21 August 2019

MPE Stage 2 MOD 2 (SSD-7628-Mod-2) and MPE Concept MOD 3 (MP 10_0193 MOD 3)

Response to Submissions

SCALE 1 : 20

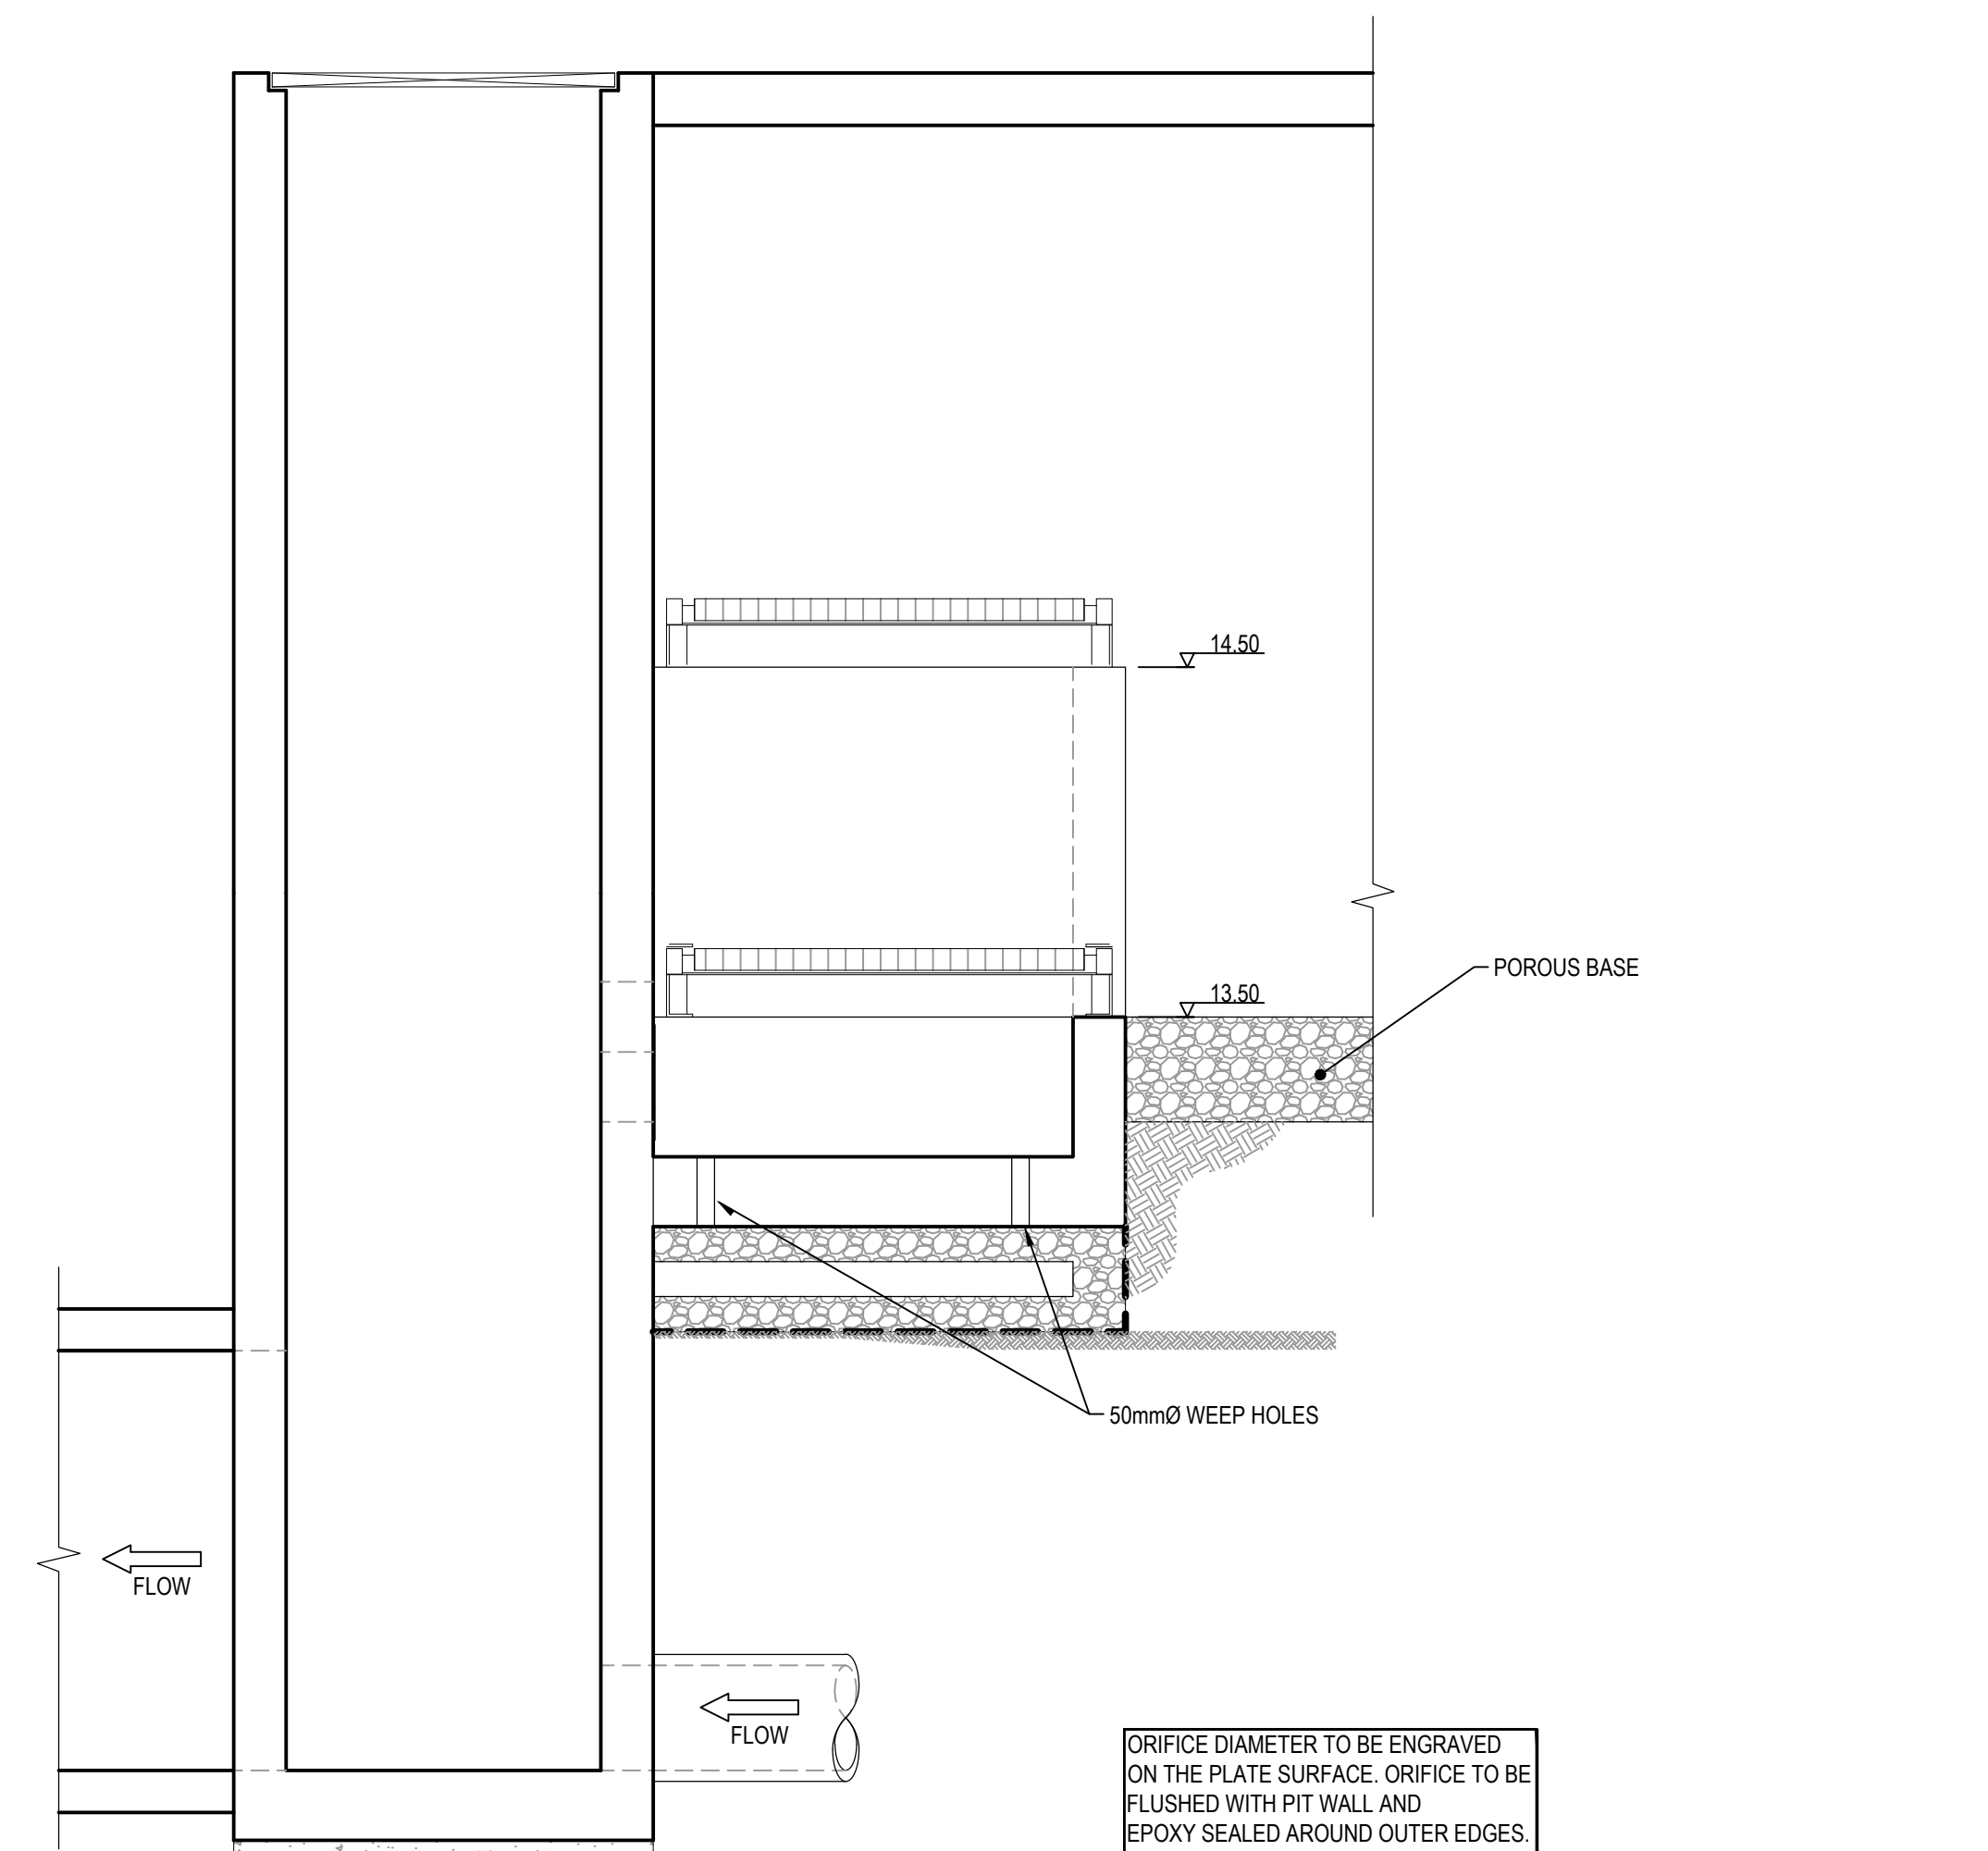
OSD basin 9 design changes

Insufficient detail has been provided in the modification application to enable the Department to complete its assessment in relation to:

- how the drainage design has been modified
- how the modified drainage design will function, particularly in relation to stormwater treatment.

- consolidated drawings showing OSD basin 9 (plan views and cross sections), including existing and finished surface levels, and the downstream bioretention area/ raingarden in the MPW site. It is recommended that you provide your most detailed drawings, such as work-as-executed drawings, in order for the Department to verify that the design can comply with relevant consent requirements
- construction schedule for installation and commissioning of the raingarden and repair of the existing open concrete channel (aka the 'east-west channel') on the MPW site
- details for treatment of stormwater from OSD basin 9 (plan views and sections), prepared by a suitably qualified professional, post-development of MPW Stage 2 (if approved).

**OSD BASIN STORAGE DETAILS**

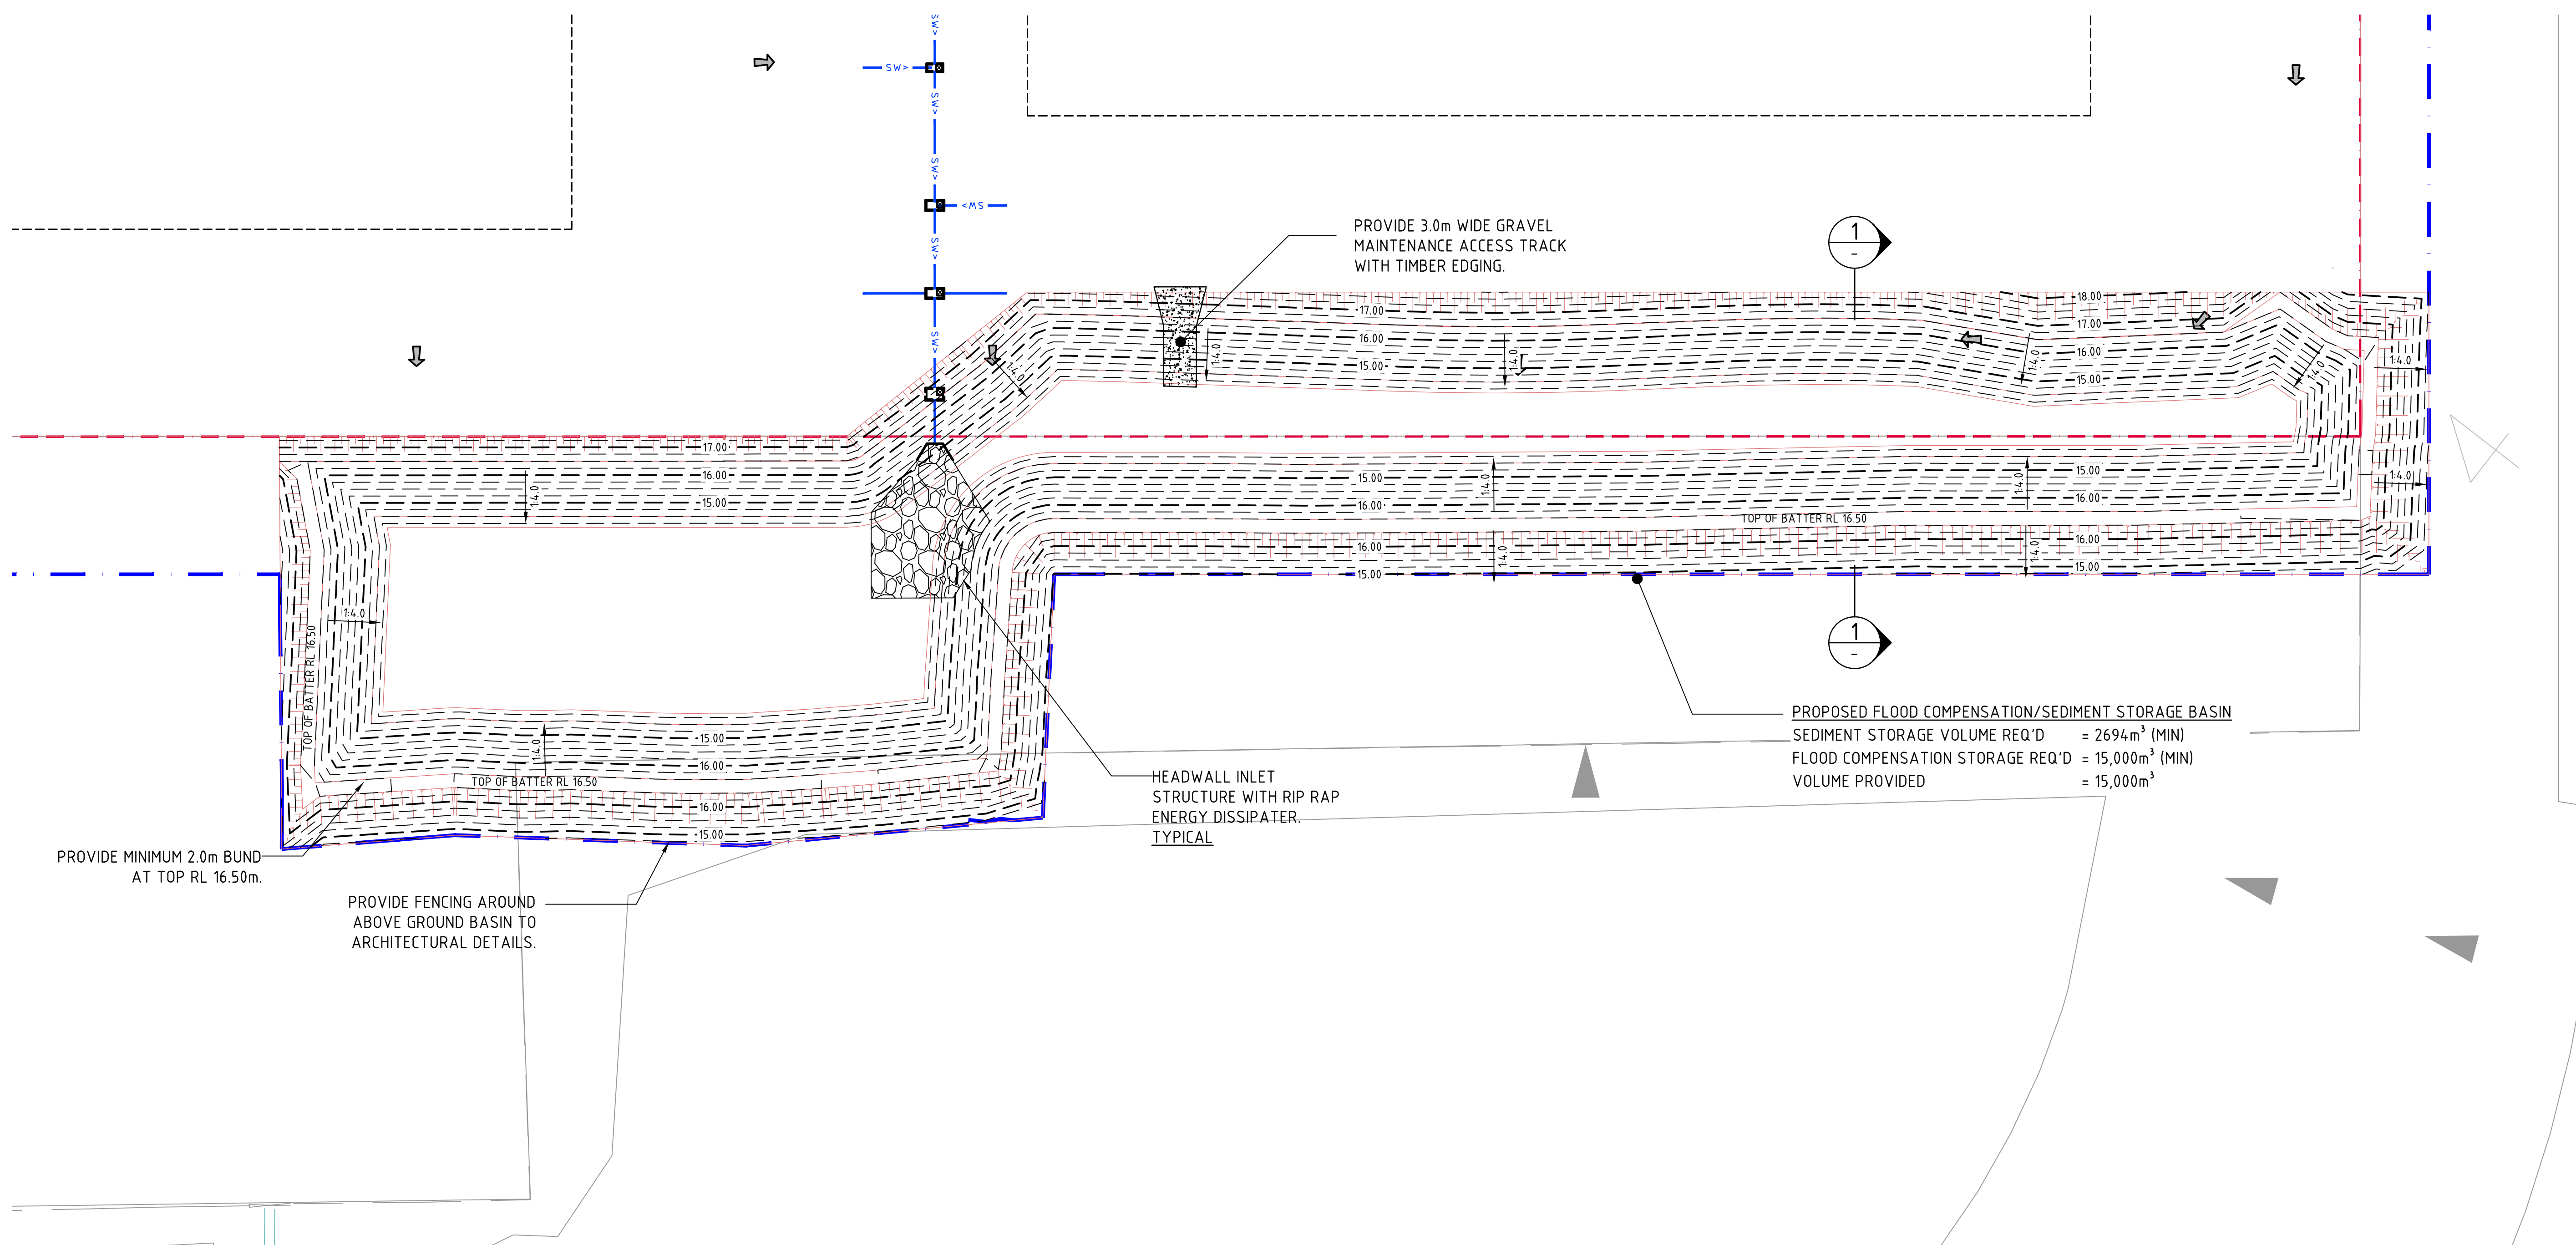
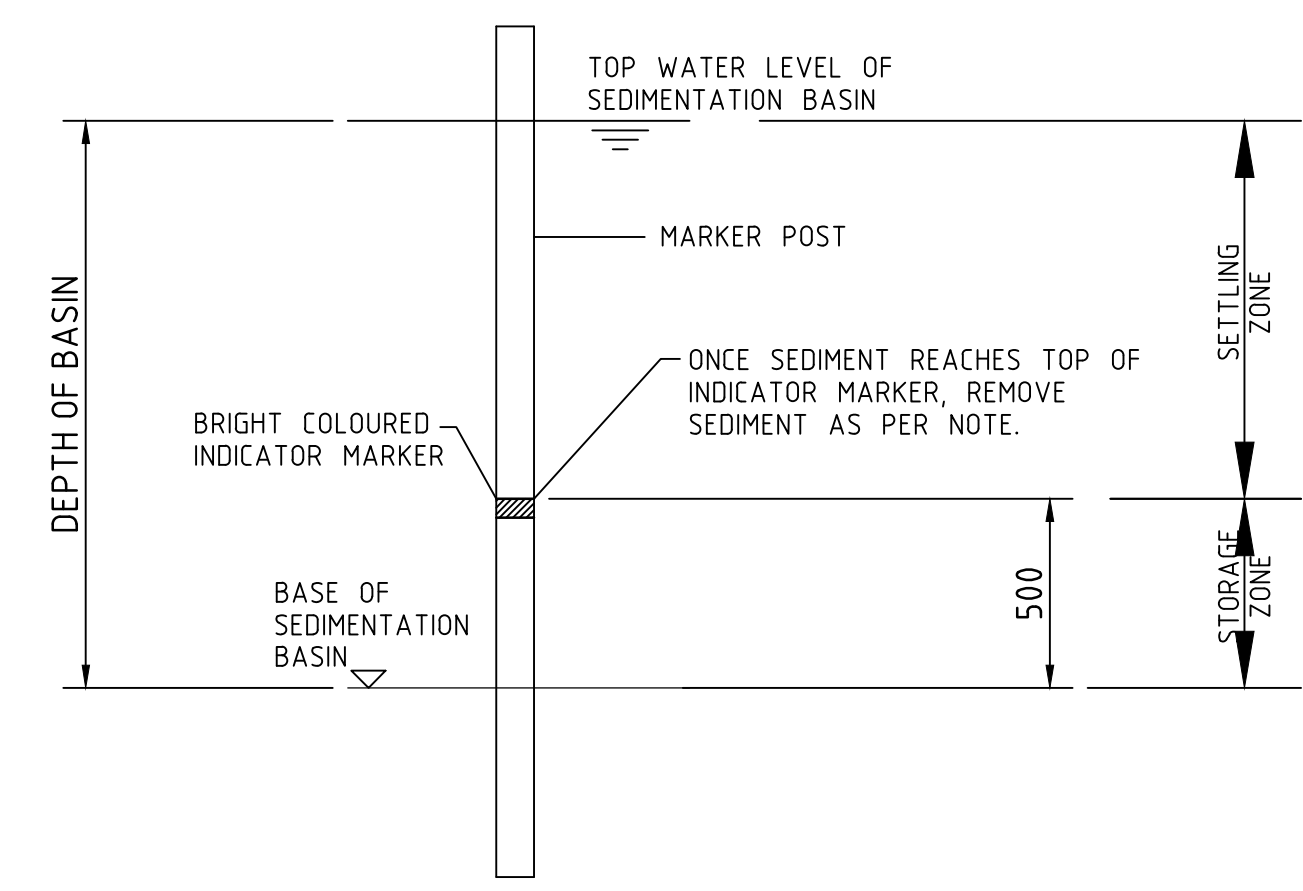
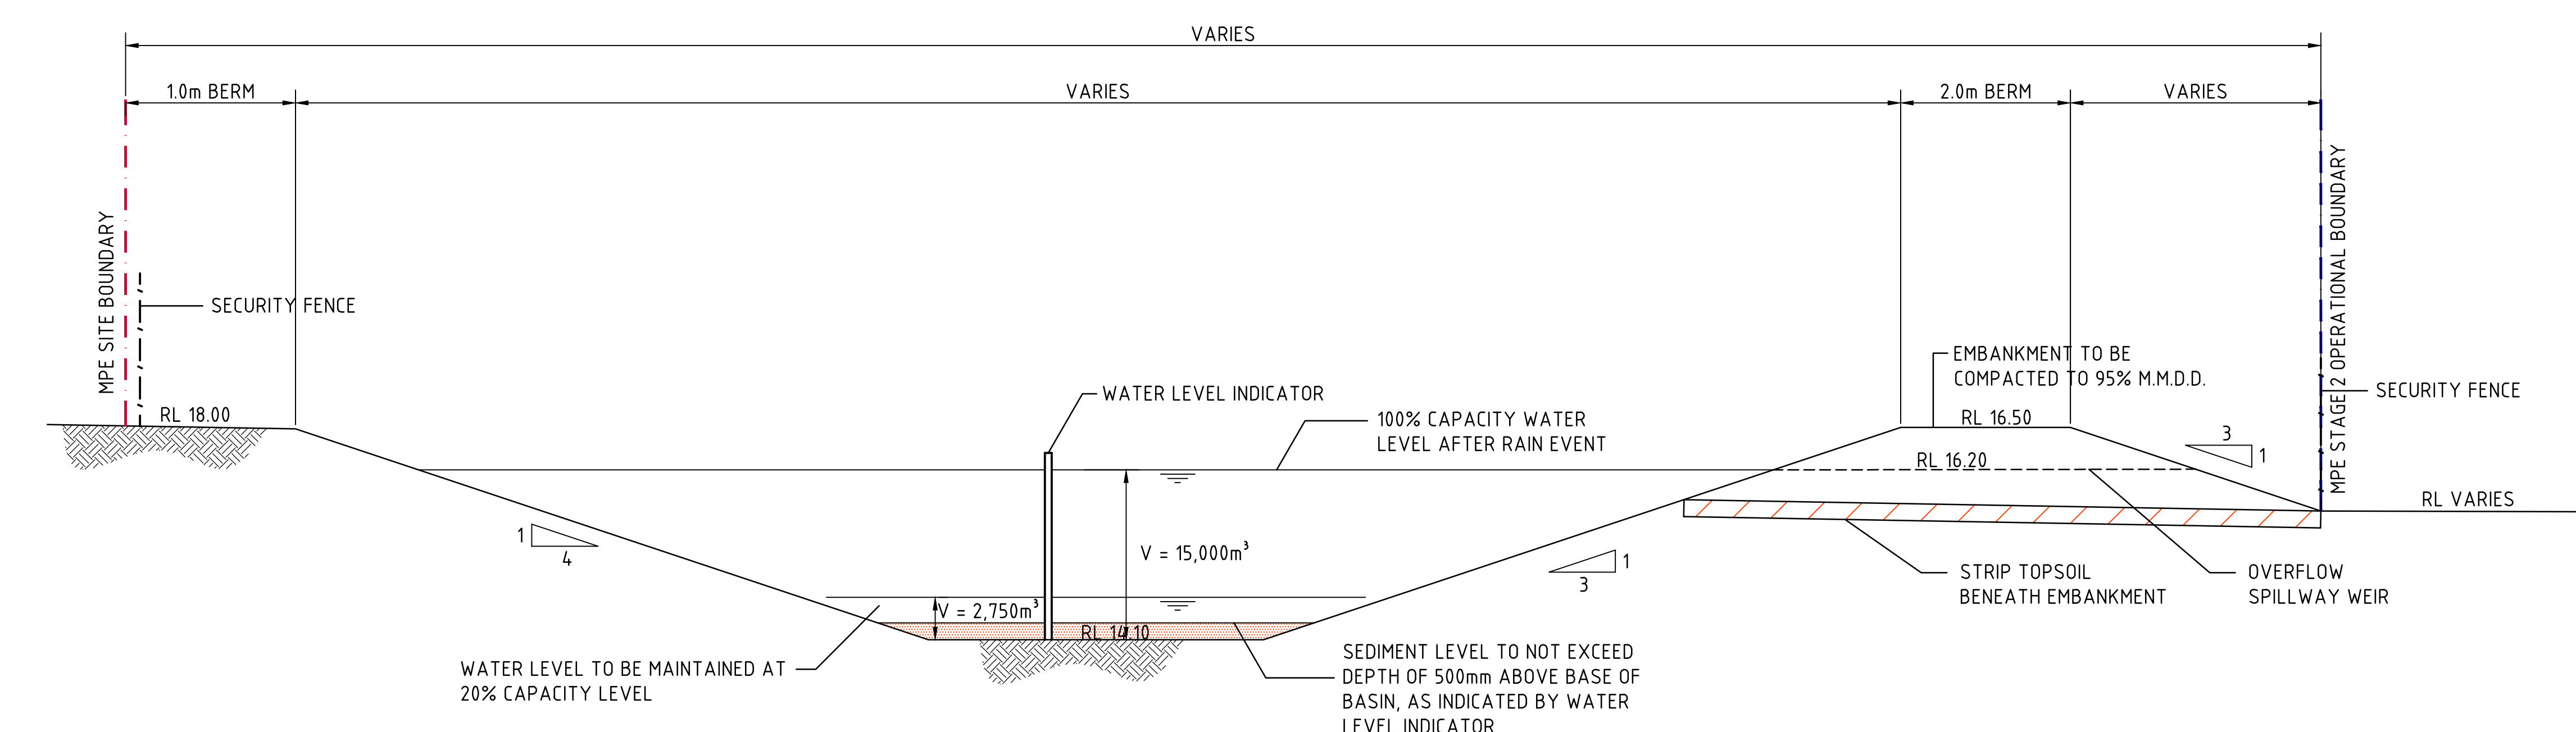
The Department is concerned that the proposed OSD basin 2 concept design as presented requires the removal of additional threatened plant species and could result in additional habitat/ riparian corridor impacts, and requests that you provide:

- a consolidated description of the justification for locating OSD Basin 2 outside the existing site footprint, with reference to existing physical site constraints, and demonstrating that this land would be used for drainage and not other uses (such as warehousing etc.)
- information demonstrating how consideration was given to minimising impacts to threatened species through the design development
- alternative layouts (sufficient for maintenance access and transition to existing ground levels at the site boundary) which avoid threatened plants or reduce the area/ number of threatened plants impacted.

Drawings are to include dimensions of the basin footprint, distances to the Anzac Creek riparian corridor and the width of the riparian corridor at a scale of 1:500 @ A1.
